Client: R. W. Gillespie & Associates, Inc.
Project: 667 Congress St. Apartments
Date: June 3, 2016
Subject: Site Inspection of Structural Steel

1565-001
Report: 001

SECTION A
1 1/2"=1'-0"
TYPICAL HSS6x6x1/4 BRACE END CONN

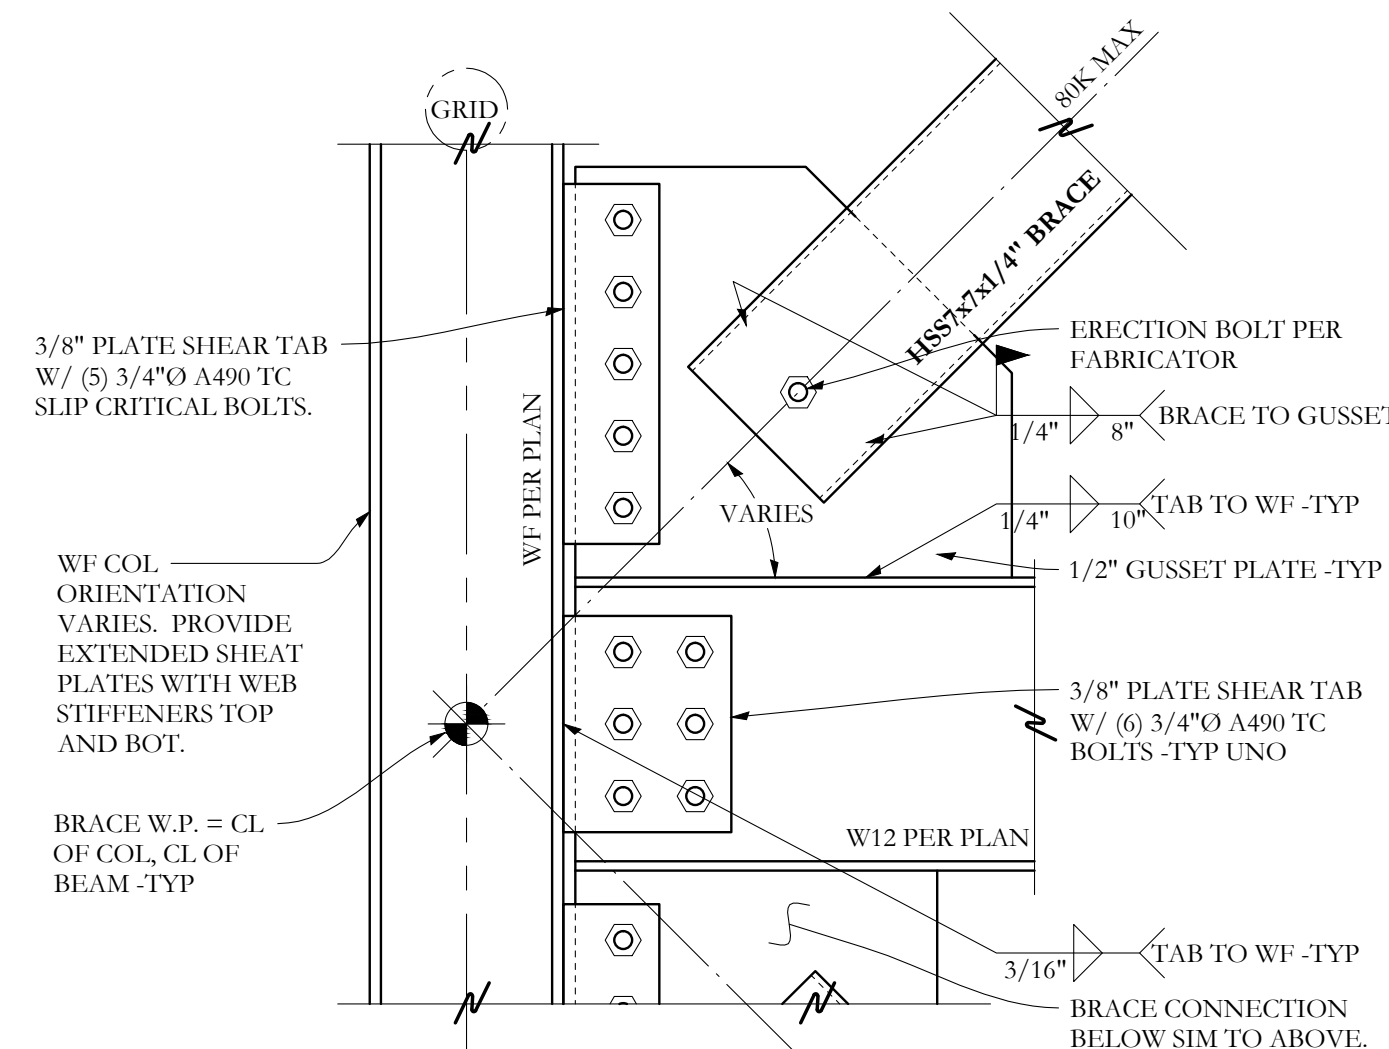
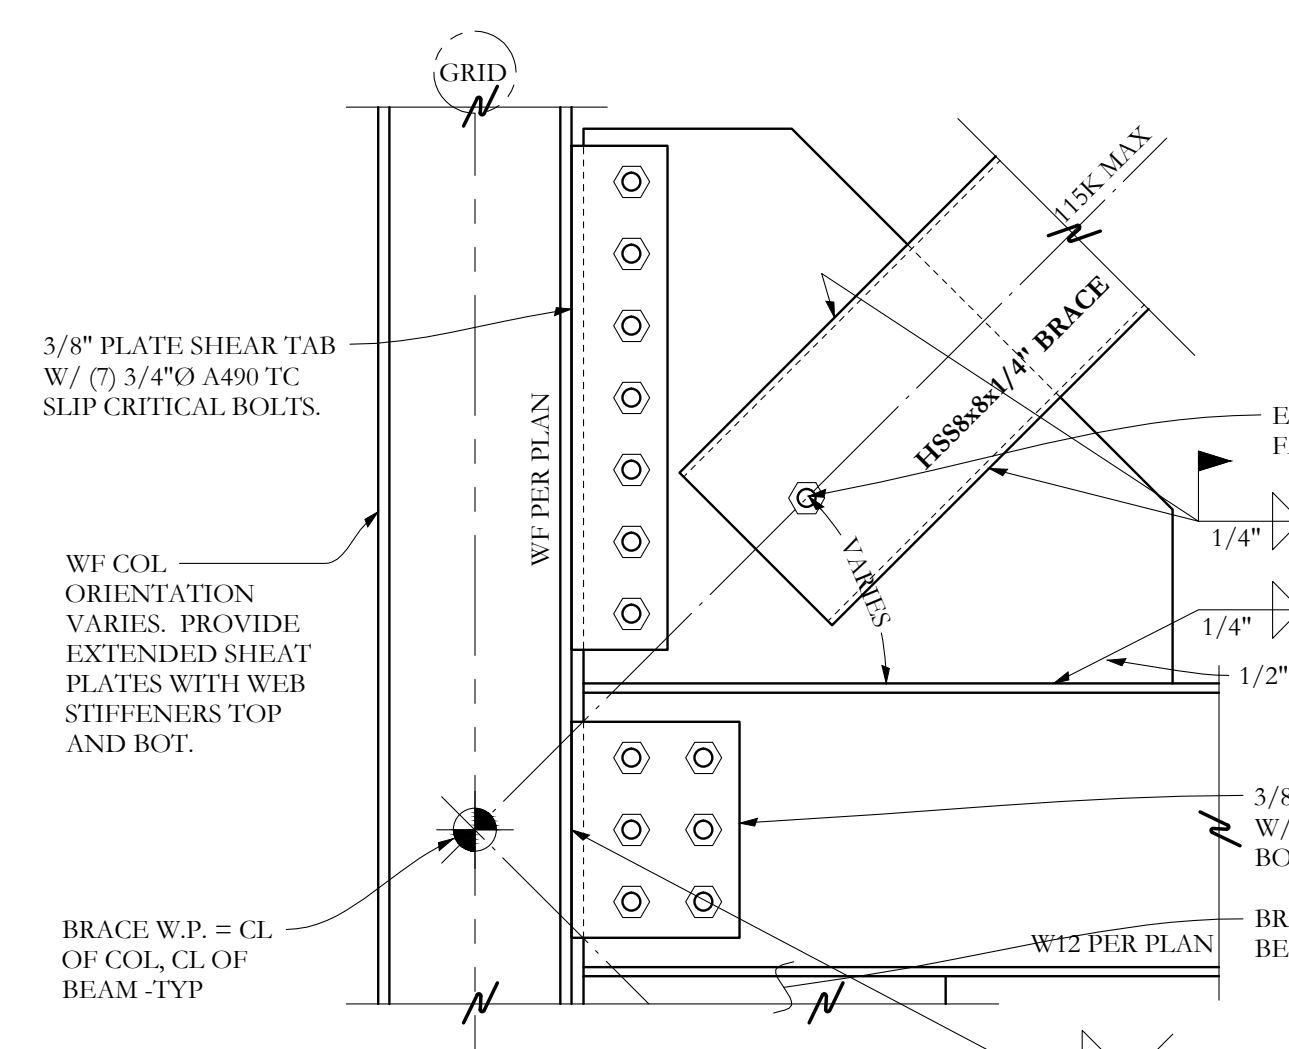
1. Bolted connections at the thermal break near line M.9 still need to be tightened.
2. The slots in the clips at the ends of all beams at the east elevation from line H to M.9 were fabricated with $\frac{3}{4}$ " slots when 1" bolts are required. The erector will ream the slots to accommodate the correct diameter bolts.
3. One weld was found to be missing on the HSS brace frame at N/4.0.
4. Deck support angles will need to be added at the east elevation as needed.

1. Several loose bolted connections were found at the Level 1 framing.
2. Some locations of the Level 1 composite deck were found to have missing puddle welds and/or side lap screws.
3. Random shear studs were found to have deficient welds.
4. One weld was found to be missing on the HSS brace at P/6 between Levels 1 and 2.

1. Three connections on the Level 4 framing were found to have one bolt hole misaligned.
2. One weld was found to be missing on the HSS brace at P/5.6.
3. Decking and studs were left out on Level 3 between H/4 and H/5 for ladder access to Level 3.

1. Welds still needed to be added to the upper end of the HSS brace at F/2.

1. Complete See Inspection Report # 3
2. Complete See Inspection Report # 2
3. Complete See Inspection Report # 2
4. Complete See Inspection Report # 2

- The missing weld on the HSS brace between grade and Level 1 at N/4.0 was added and found to be acceptable. (Item 3 6/3)
- Deck support angles were added at the east elevation and appeared to be properly fastened to the foundation. (Item 4 6/3)

- The missing weld on the HSS brace at P/6 between Levels 1 and 2 was added. A visual inspection of the weld was performed. (Item 4 6/14)
- All anchor rod nuts in the basement were properly tightened and column base plates were found to have proper bearing.
